CITY OF ALBUQUERQUE

Aug. 14, 2017

RE: **Premier M.H Display Yard**
Grading Plan
Engineer's Stamp Date 8/4/17
Hydrology File: M14D012C2

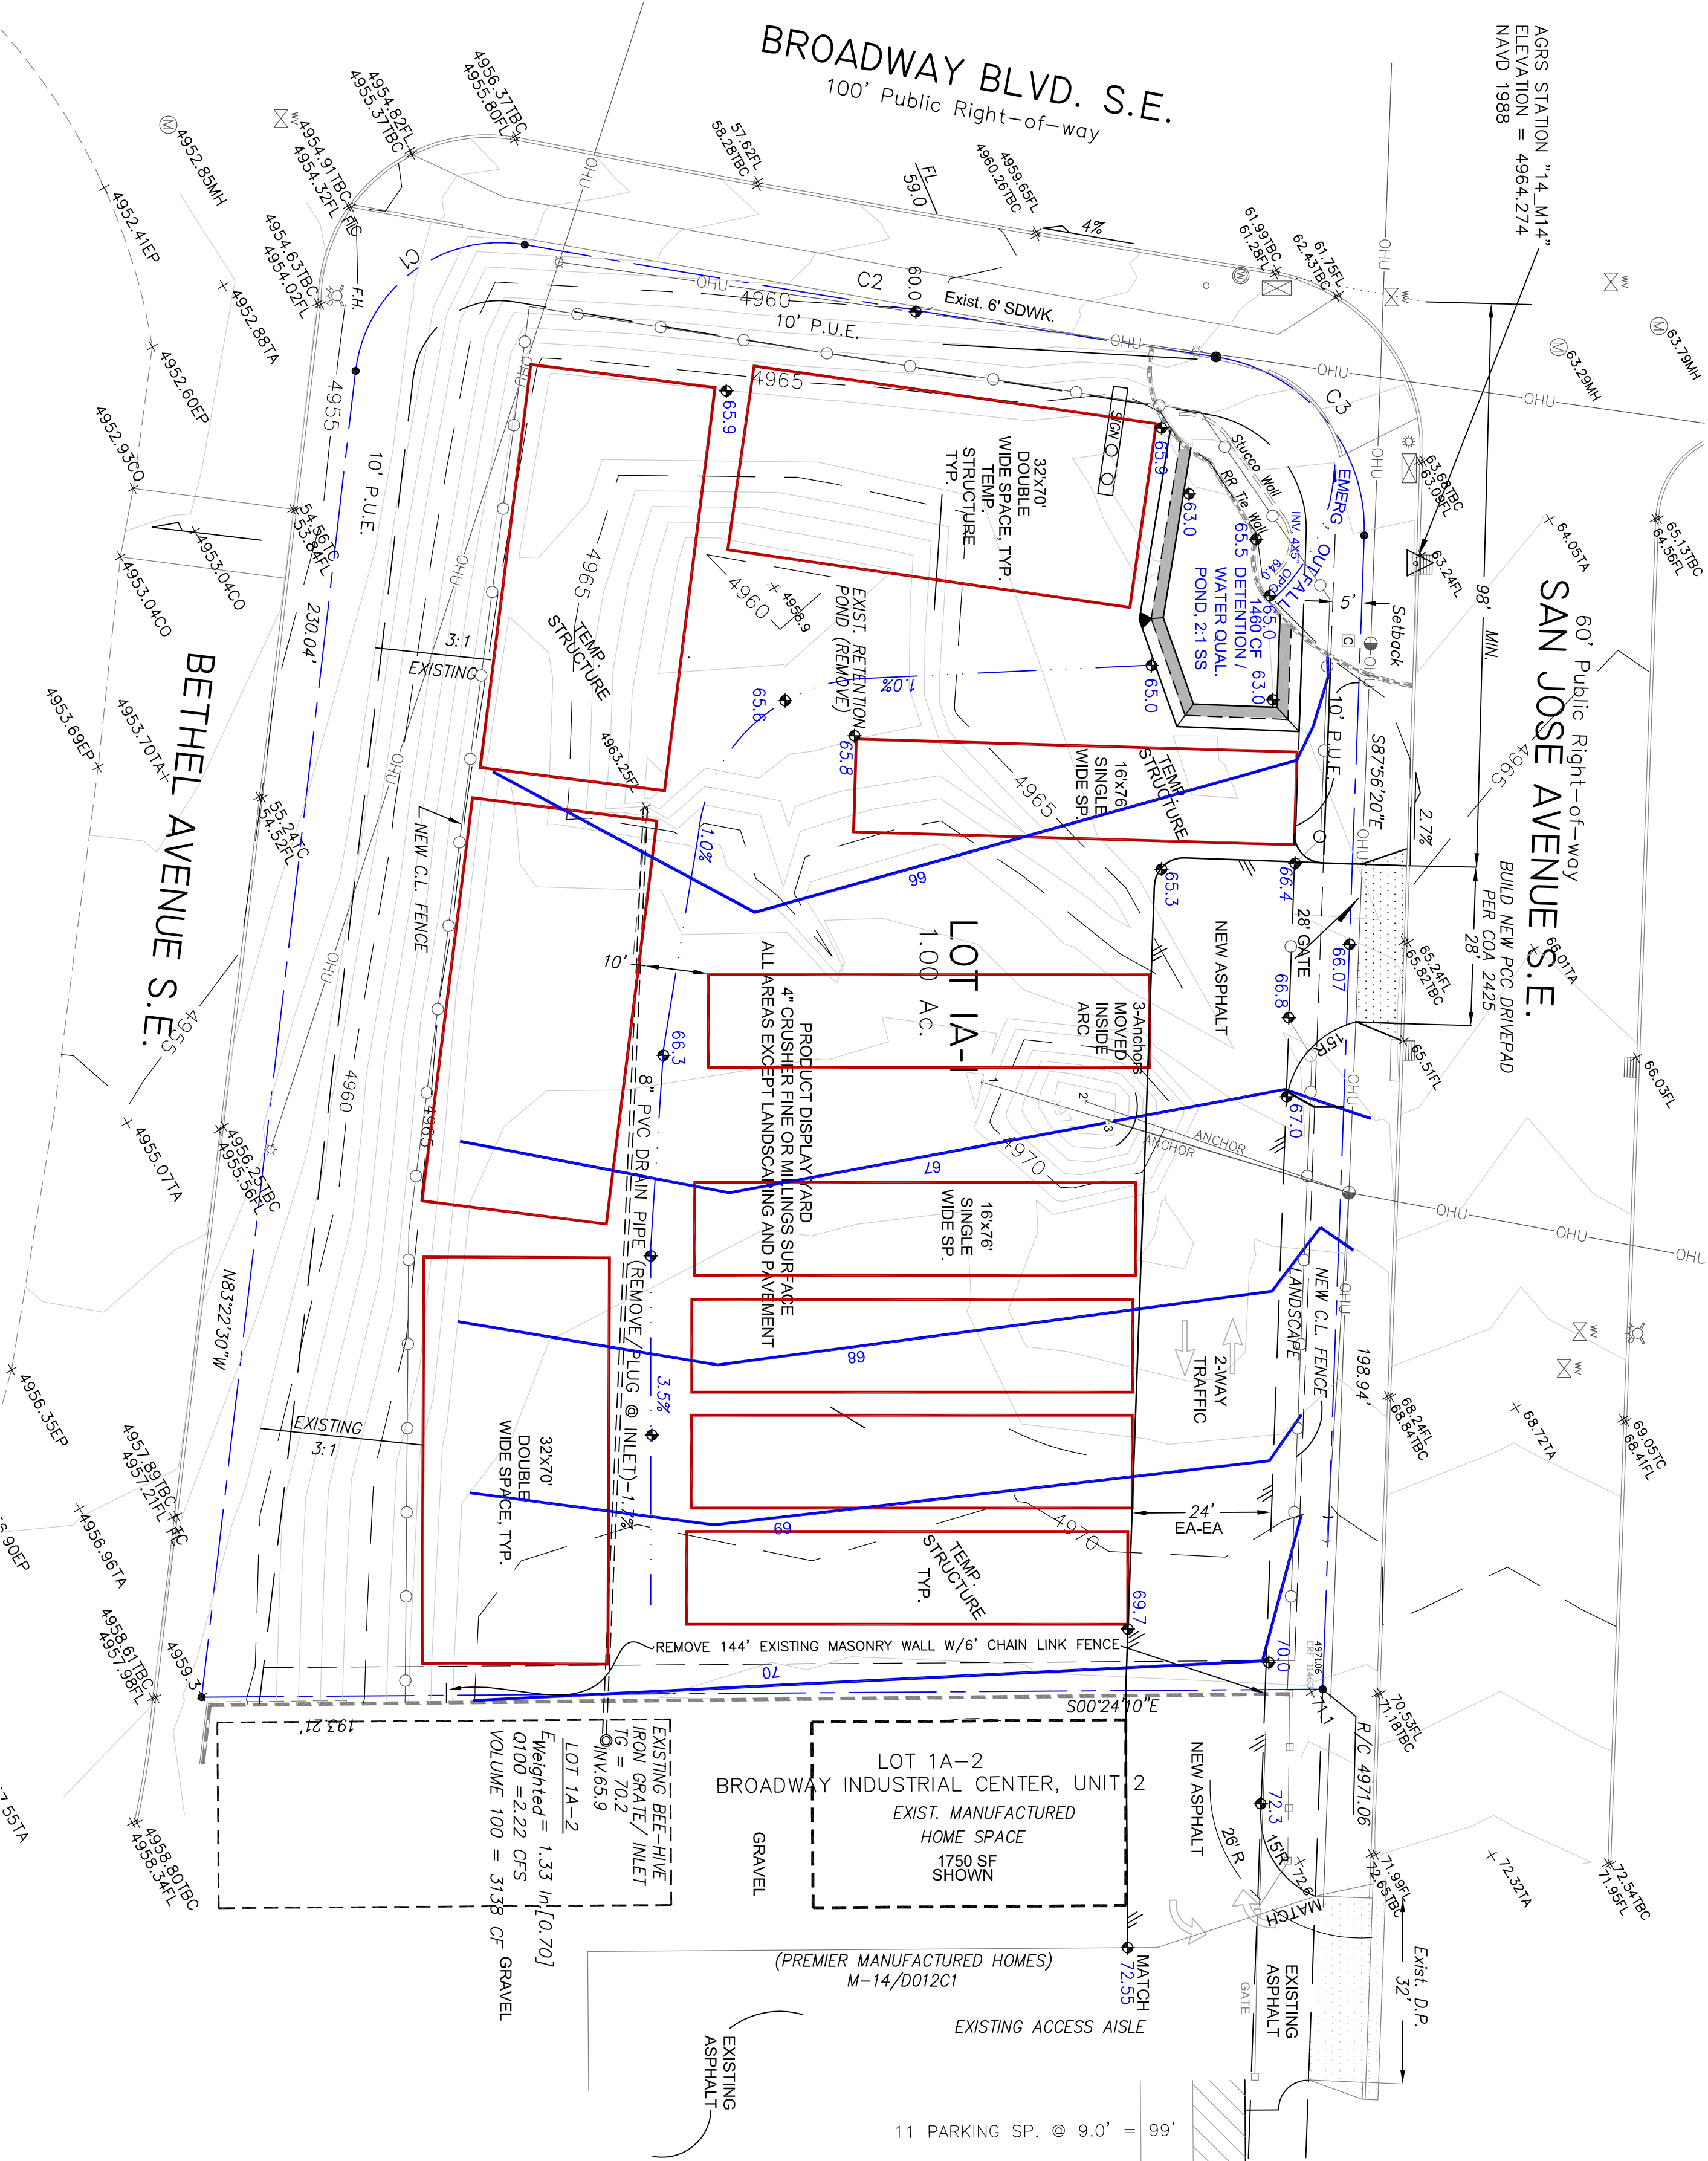
1. The Grading and Drainage Plan notes should start by stating the drainage management plan for the site. The drainage management plan for this site was established when this property was subdivided in 1997. This site will ultimately be allowed free discharge after downstream storm drains are constructed, but until then this site must retain all of the runoff from the 100 year 10 day storm. Storm drain in Bethel Ave is required infrastructure to be constructed by this development as frontage improvements prior to allowing free discharge from this site. AMAFCA's 2018 Project Schedule identifies additional projects to provide an adequate outfall south of Bethel.

2. Drainage problems along Arno and Broadway are still unresolved, so temporary onsite retention is still required.
3. The drainage infrastructure in San Jose Ave. and Broadway Blvd. is not designed to receive any drainage from this lot, so drainage will not be allowed to discharge to either of those two streets. The statement in the Grading and Drainage Plan that says "The current pond will be removed since upstream detention has been provided with development" is unfounded and should be deleted unless that analysis is added to this project in the form of a report.

4. Offsite basins, lot 1A-1, must be clearly shown on the plan (or on a separate basin map) using a base map that includes property lines contours, and all storm drains, roads, C&G, ditches, and berms as necessary to support the chosen location of the basin boundaries. Flow arrows should be shown on the map indicating concentrated flow paths especially at the point of discharge from each of the basins.

5. If this project does not provide a report to demonstrate the adequacy of the San Jose and Broadway storm drains then all of the runoff from the 100 year 10 day storm

must be retained onsite including the runoff from lot 1A-1 east of this site. Runoff from the slopes on the south and west sides of the site should also be retained. The emergency overflow spillway needs to be sized to pass the peak inflow with 1' of freeboard,

6. If capacity is demonstrated in San Jose and a detention pond is to remain part of the drainage management plan then Additional detail is required for the pond outfall. The pond hydrograph calculations state two 4x5" openings will be used but no details are provided.

7. The topography certification can be removed sense that is a Bernalillo county requirement and not a City of Albuquerque requirement. Instead please add a note identifying the source of the topographic information including the surveyor's name and professional registration number.

8. The floodplain note should include the flood insurance rate map number and the effective date. This note should be included in rest of the drainage notes on the sheet rather than being randomly placed on the sheet.

9. The Statement "A Former Approved and Graded Site" is inappropriate as a title to the 4 notes that follow the statement.
10. Provide cross lot drainage and access easements for lots 1A-1 and 1A-2.

11. A Drainage Covenant will be required for the new pond.
12. Written approval must be obtained from PNM to move their guy wires and work in their easement.

13. Written approval must be obtained from the owners of lot 1A-2 to remove their wall.
14. The new driveway entrance off San Jose cannot be placed over the transition slab for the existing inlet. The d

15. An approved ESC Plan is required for this site.
